From: Daniel O'Shea [REDACTED]
Sent: 05 February 2020 16:45
To: Simon Davis <Simon.Davis@arun.gov.uk>
Subject: RE: P/70/19/RES - Land N of Summer Lane, Pagham

From: Simon Davis <Simon.Davis@arun.gov.uk>
Sent: 05 February 2020 15:57
To: Daniel O'Shea [REDACTED]
Subject: P/70/19/RES - Land N of Summer Lane, Pagham

I have just had a conversation with a neighbouring resident who is concerned about the impact on his amenity/privacy from plots 2 and 3 which face towards the rear of his house (5 Sylvia Close). I have explained that the interface distances between the new plots and the existing houses in this location are well above our standards, however, he has requested that we ask you whether there is any scope to re-jig this part of the site (plots 1-3) to enable the two storey dwellings (plots 2 & 3) to have their flank walls facing east towards his property instead. I would be grateful for your response as to whether this could be possible.

PROPOSED LIGHTING LAYOUT

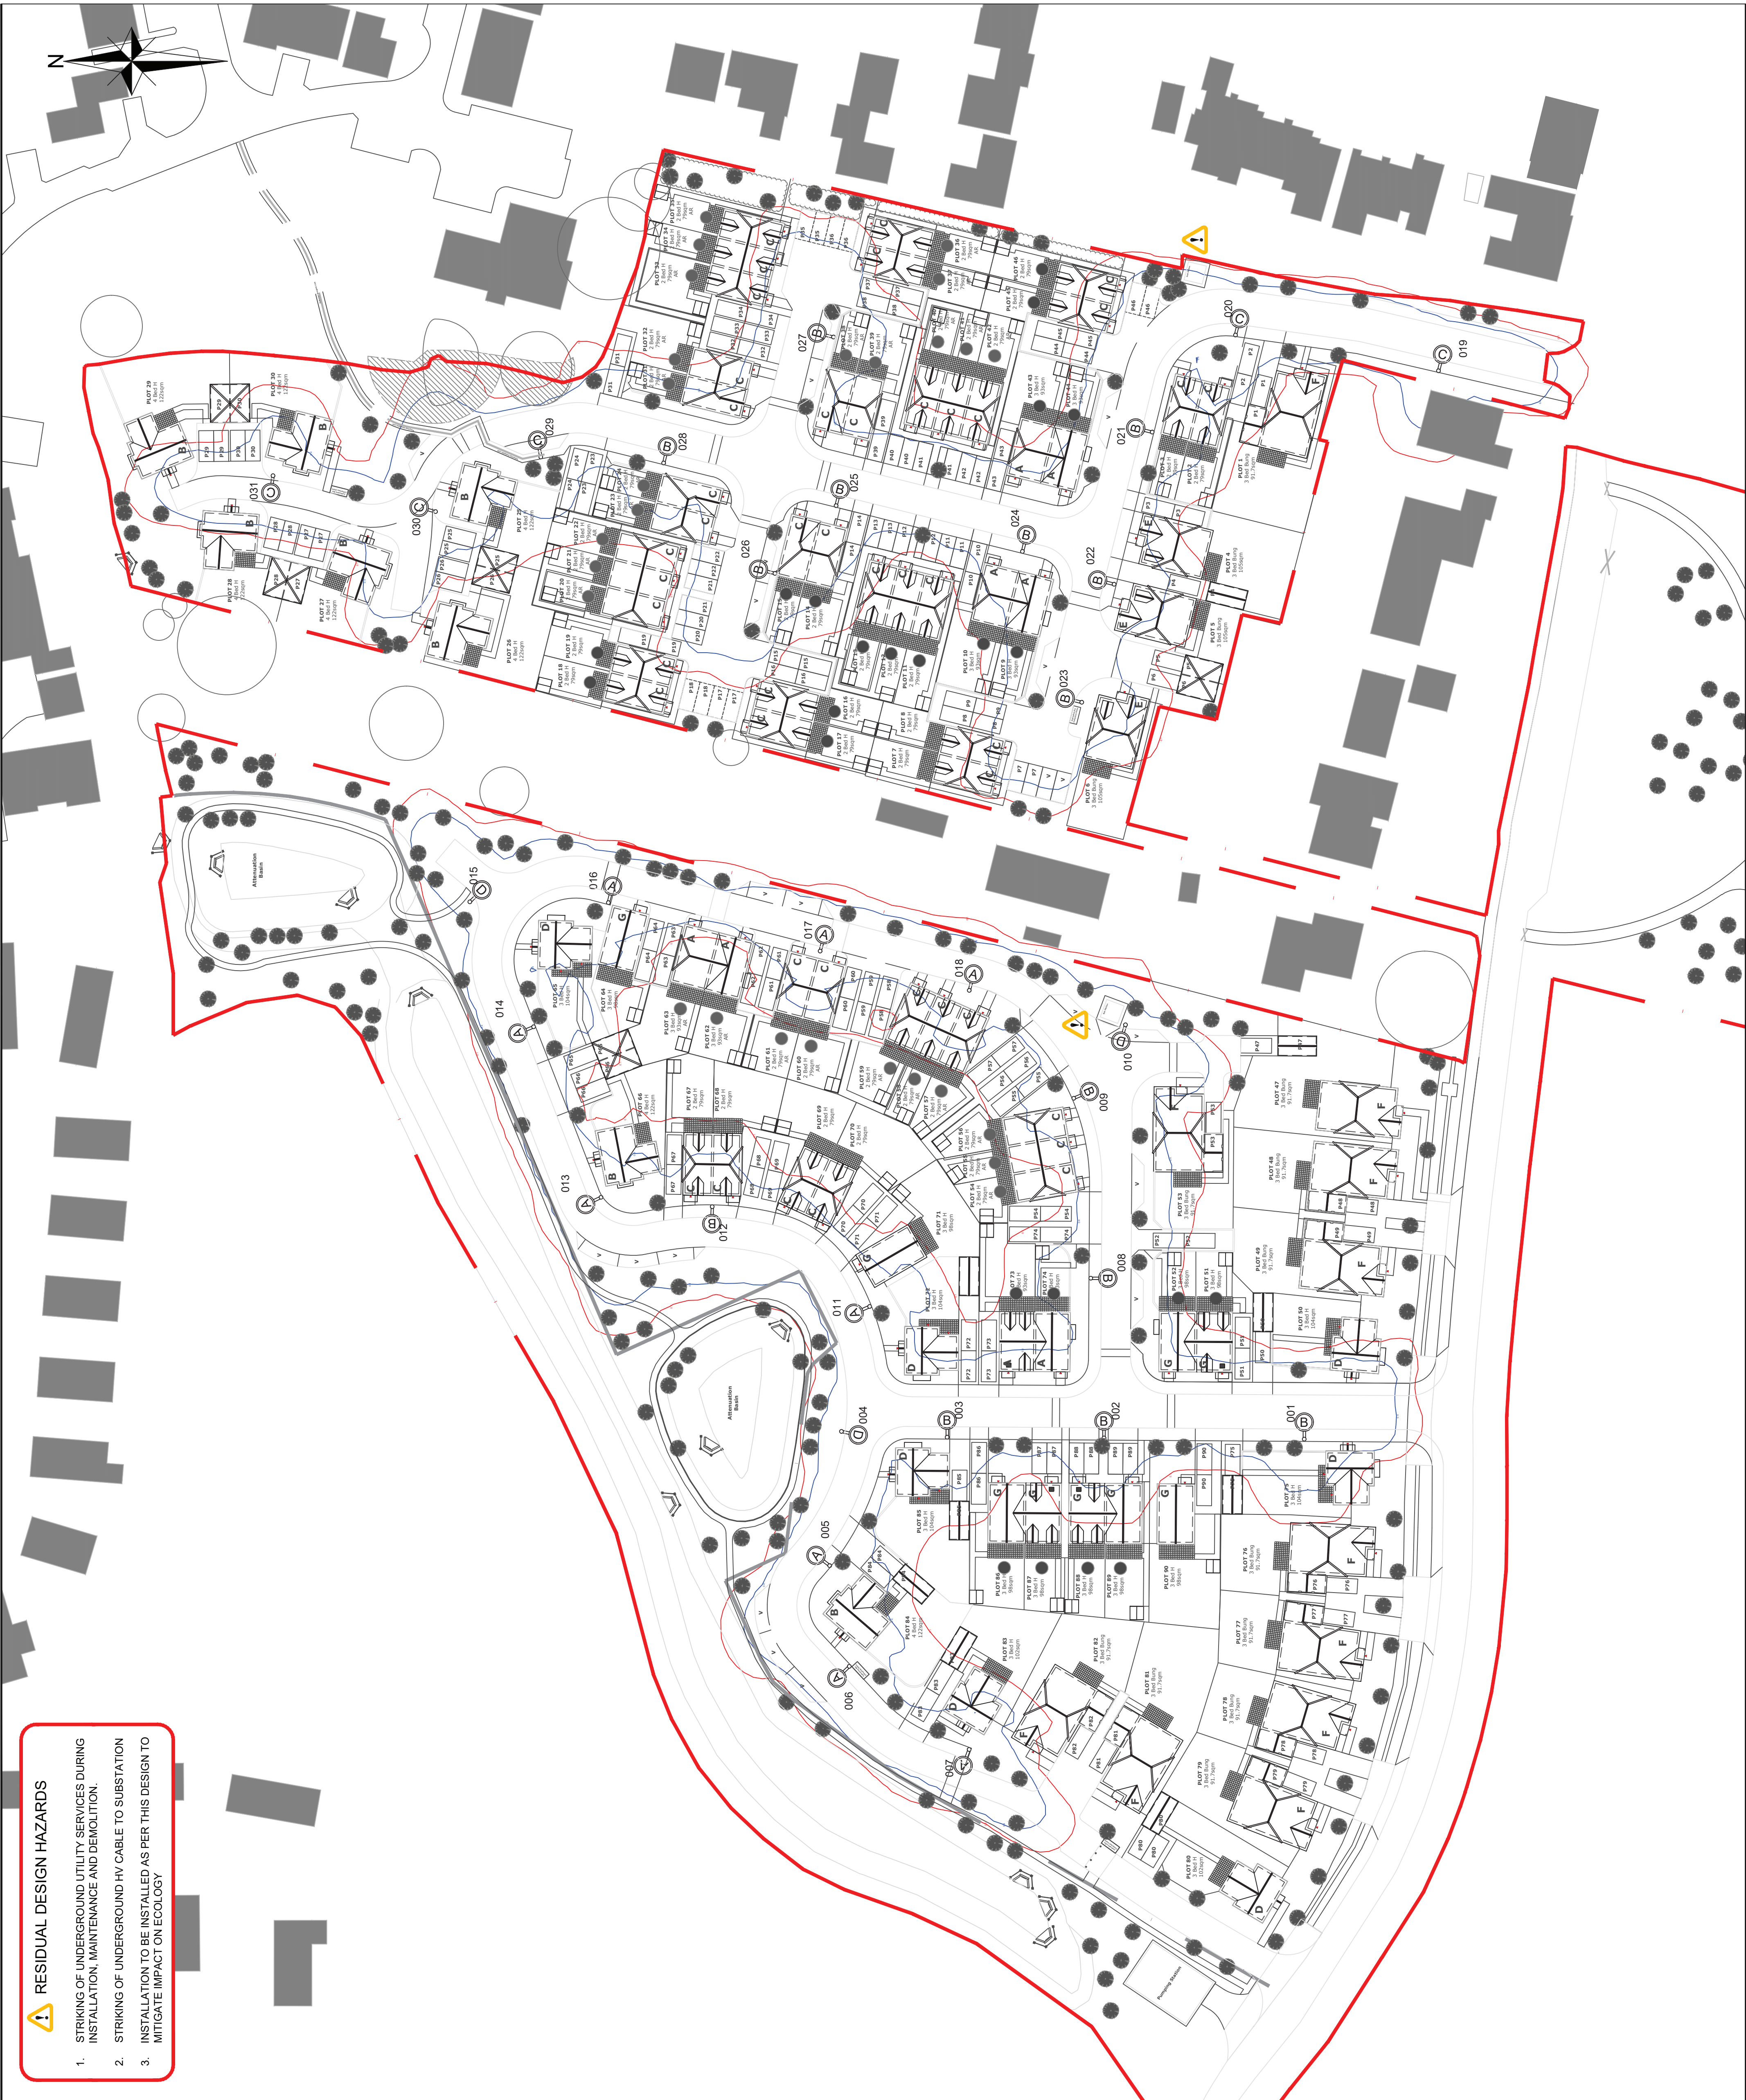
Regarding pets, despite the fact the land is currently under private ownership. The addition of significant Public Open Space, specifically for the purposes of dog walking, should help to alleviate the loss of access to land currently used. The development site itself will also become permeable and accessible to the public with a future footpath through route proposed. Drainage is obviously a general concern, but one that we are addressing through detailed design, so our proposals won't be accepted unless considered an agreeable approach. Regarding the light pollution issue, looking at the lighting design, once the light reaches the boundary the lux levels are at no more than moonlight level so should be deemed acceptable.
